Response to Comments and Submissions: Brookvale Community Health Centre (SSD 6980) Modification 2

The application seeks approval for the establishment and operation of a temporary site compound for up to 16 months to support construction of the new pedestrian footbridge at Brookvale. A response to the comments and issues are provided in Table 1 below.

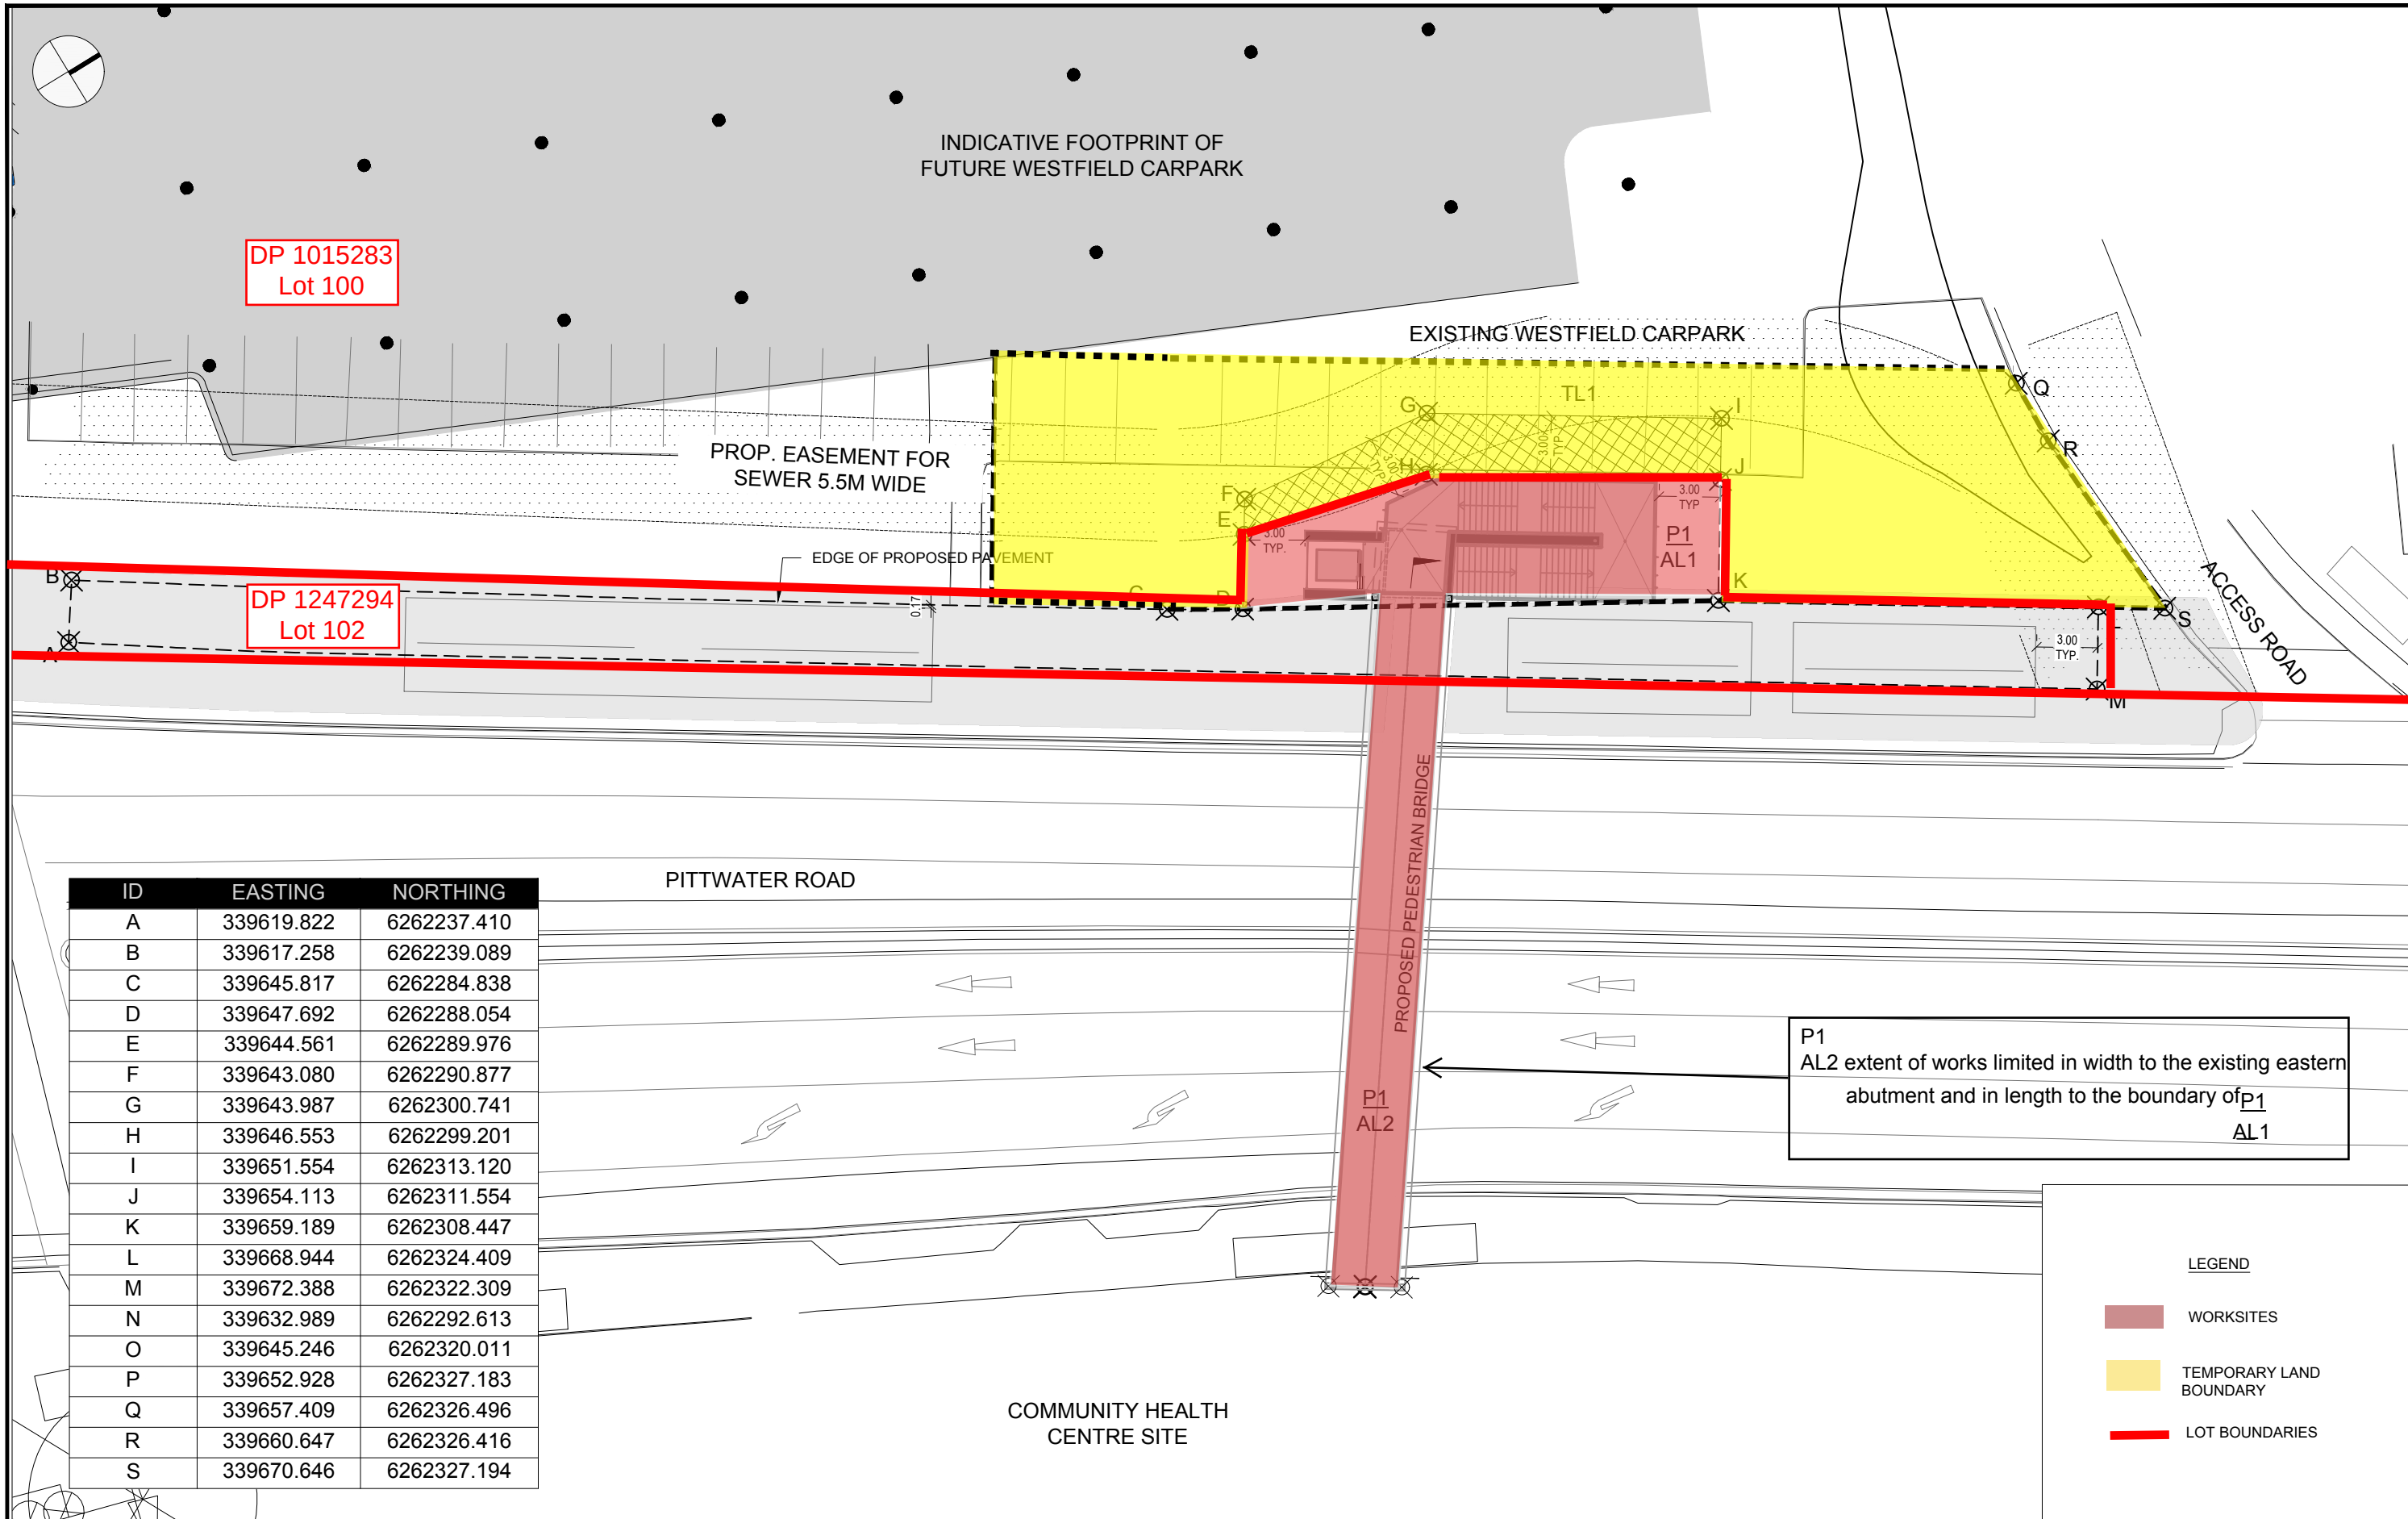
DP&E	
A revised site plan in high resolution which includes relevant lots to be provided to support the application.	A revised site plan which includes Lot and DP boundaries is included as Attachment A.
Confirmation of landowners consent to be provided to support the application.	As noted in the Environmental Assessment for the proposed modification Lot 102, DP1247294 has been acquired from Westfield by TfNSW for the new pedestrian Bridge. Landowners consent for the proposed modification request is provided as Attachment B. It is noted subsequent to submission of the modification request on 18 February 2019, consent from the landowner was received for use of this additional area to the south of the work zone for the temporary site compound. The site plan provided as Attachment A has been revised accordingly to shown the enlarged site footprint.
Clarification on the extent of earthworks for the proposed temporary site compound.	Earthworks would generally be required to level the existing raised landscaped garden area adjacent to the car park (refer to Figure 1 below).  Figure 1 Temporary site compound (view to the south) Earthworks works would extend to a maximum depth of 0.2 metres below ground level. The total disturbance for the proposed temporary site compound and associated utility connections would be around 42 cubic metres.
